DEPARTMENT OF PUBLIC HEALTH

RE: Harnett County Land Use Application 03-5-5545

On September 18, 2002, an Environmental Health Specialist from the Harnett County Health Department attempted to evaluate your property for the purpose of issuing an Improvement Permit. This individual was unable to evaluate your property for one or more of the following reasons.

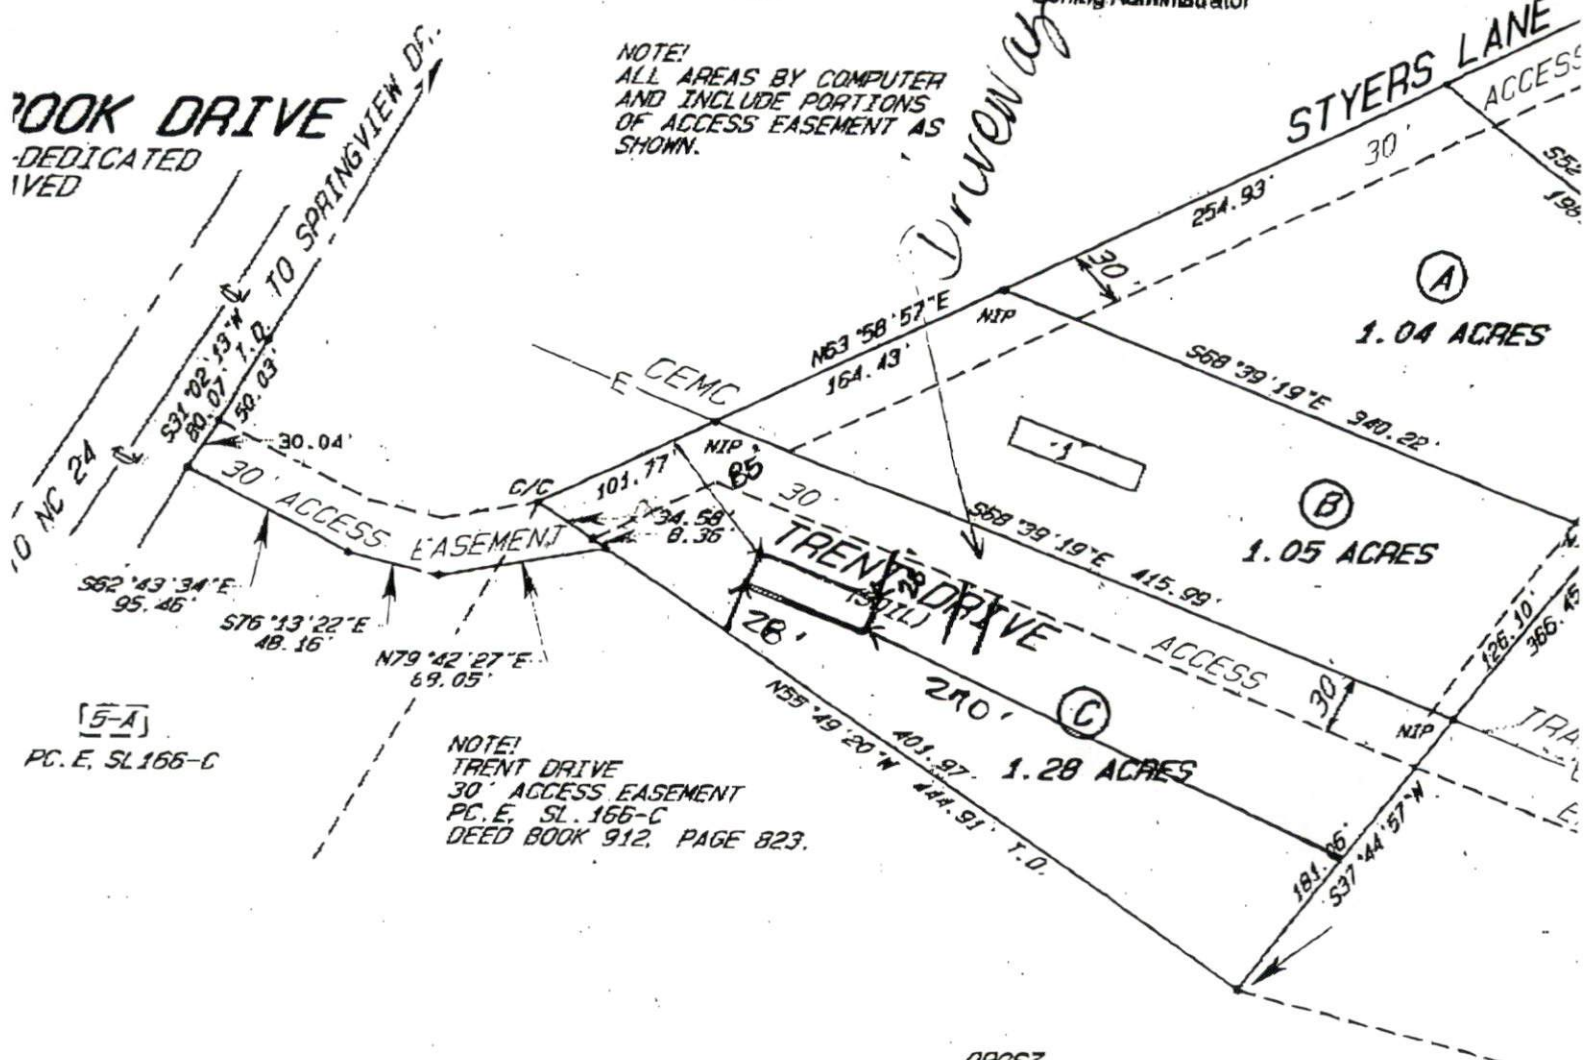
The following items must be done before any more work can be done:

1. Mark the right of way for Trent Drive.
2. Mark the right of way for the power line easement.
3. You may have to obtain written permission from the power company to put drain lines in the power line right of way.
4. Provide a copy of the survey map showing easement for road and power line.
